THE HILLS SHIRE COUNCIL
3 Columbia Court, Baulkham Hills NSW 2153
PO Box 7064, Baulkham Hills BC 1755
ABN 25 034 494 656 | DX 9966 Norwest

17 April 2025

Comments on SSD-78156221 – Mixed-use development with in-fill affordable housing

Council received a request for advice on 25 March 2025 in relation to State Significant Development 78156221 for an Environmental Impact Statement (EIS) for the Mixed-use development with in-fill affordable housing at Cecil Avenue and Roger Avenue, Castle Hill.

Drawing Title
BUILDING B - UPPER GROUND

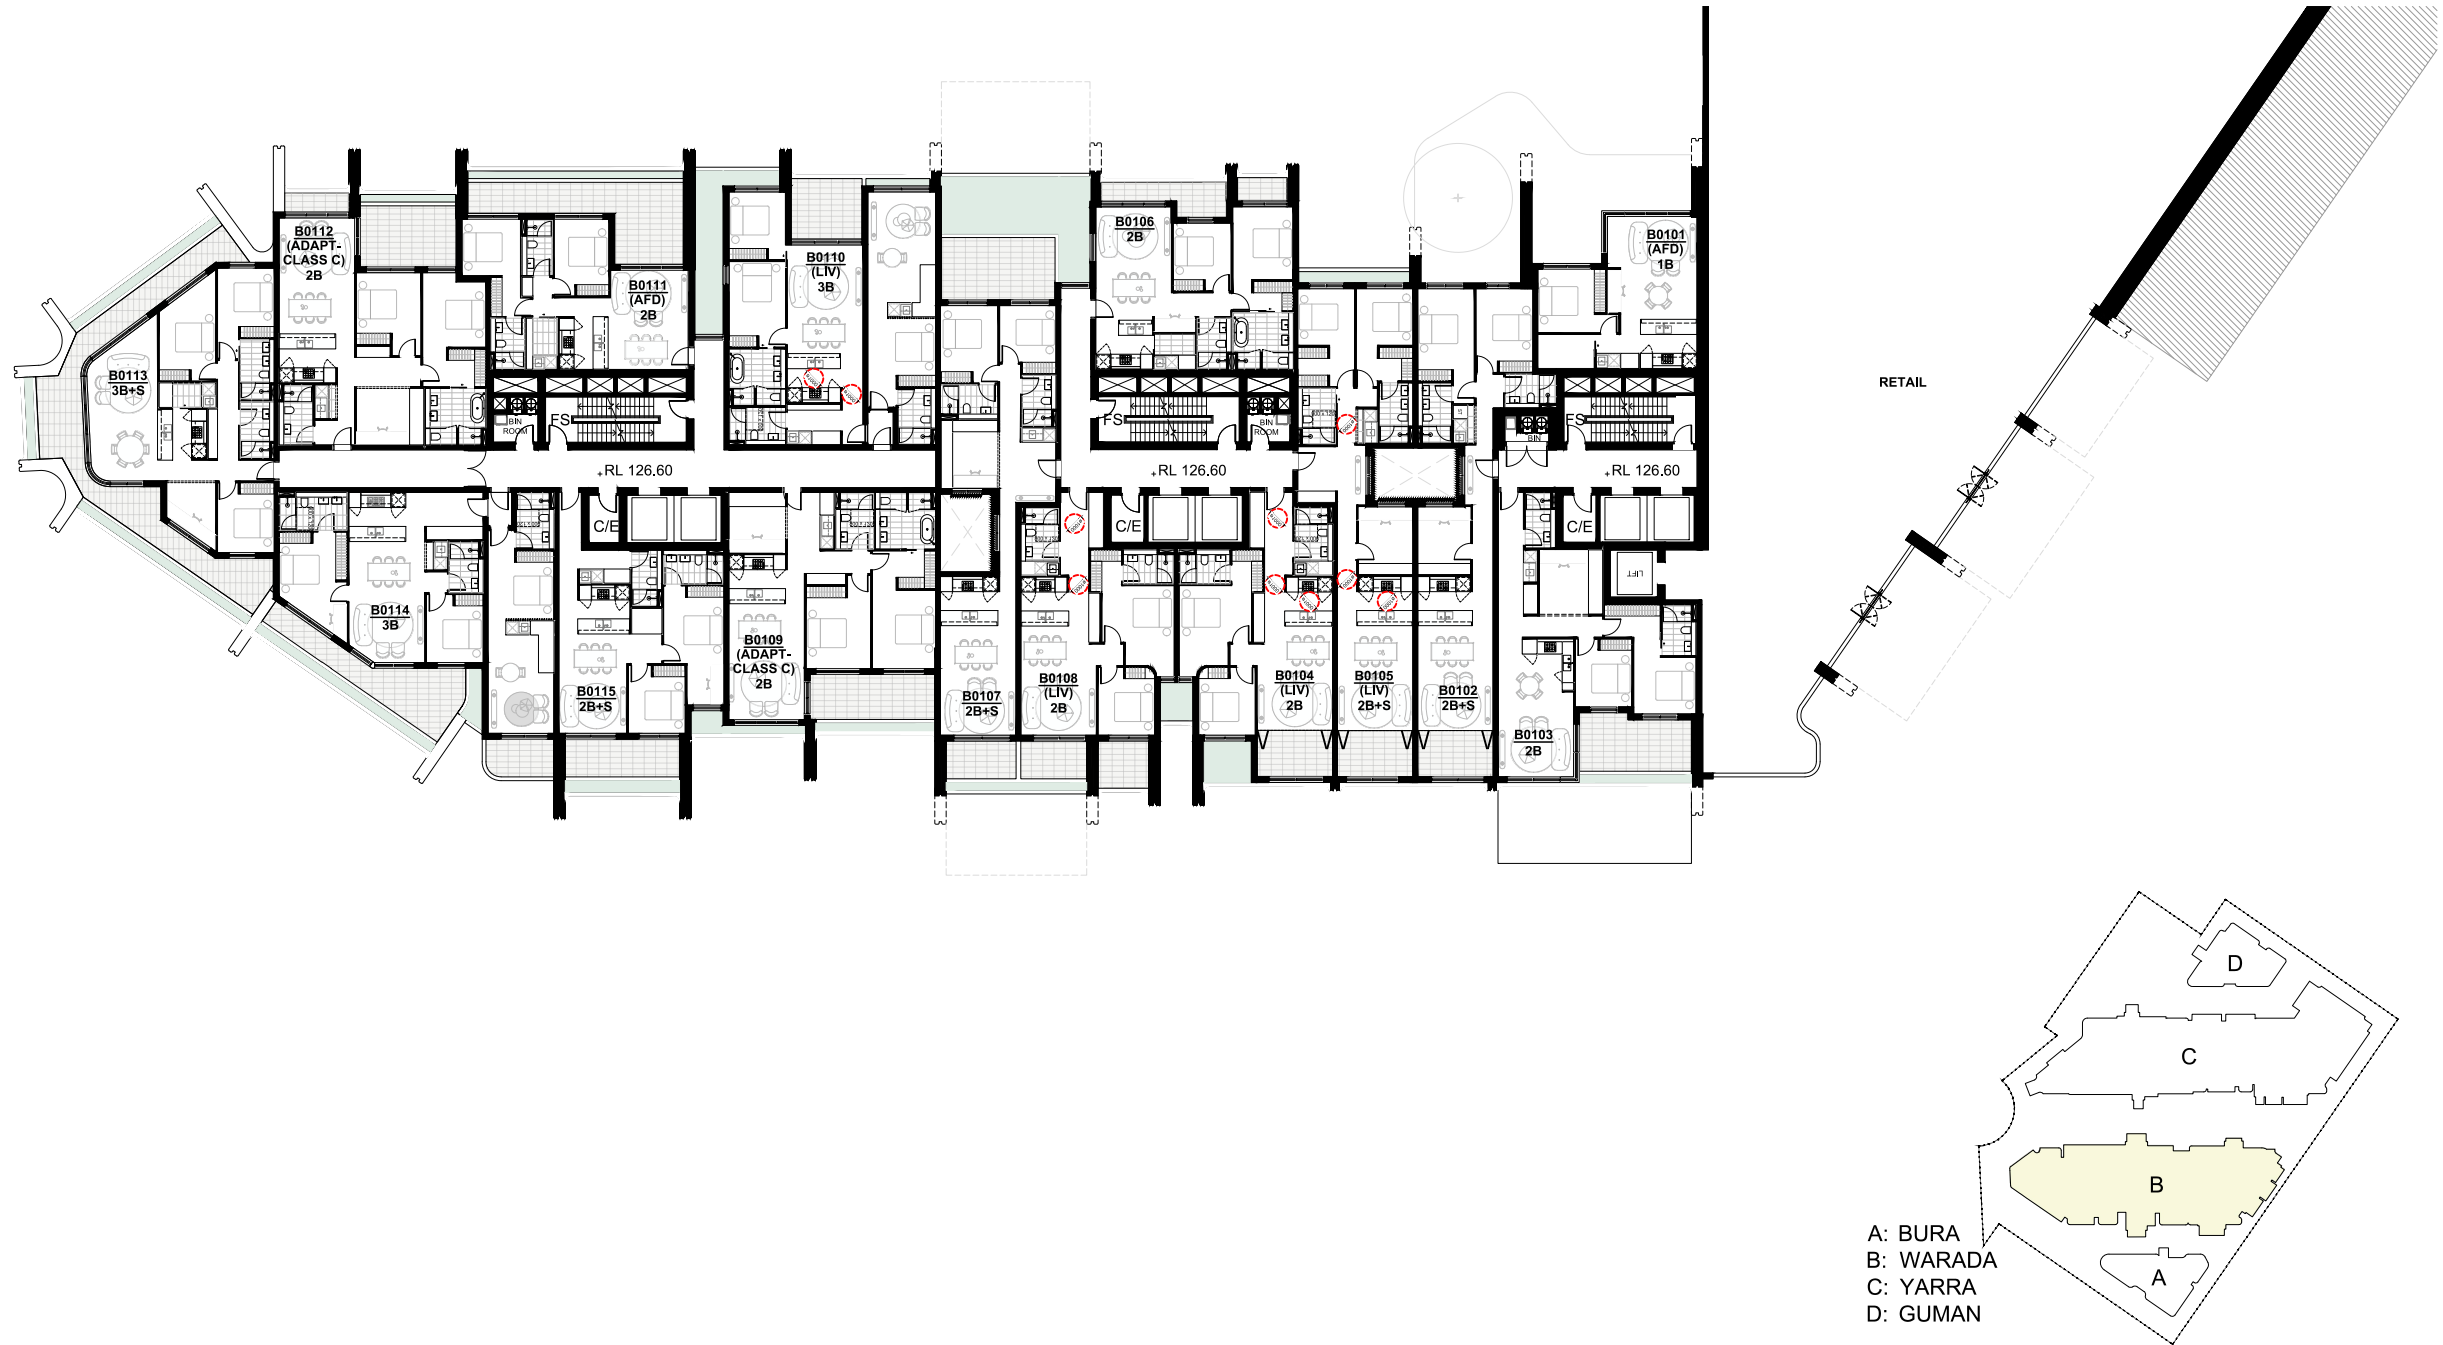
It is noted that there are multiple apartments without entry doors. An example of this on Upper Ground shows an apartment behind the stairwell and along the escape route path. There is no door noted for this apartment, nor would its access point be feasible. All apartments will need access points correctly marked prior to unit numbering taking place.
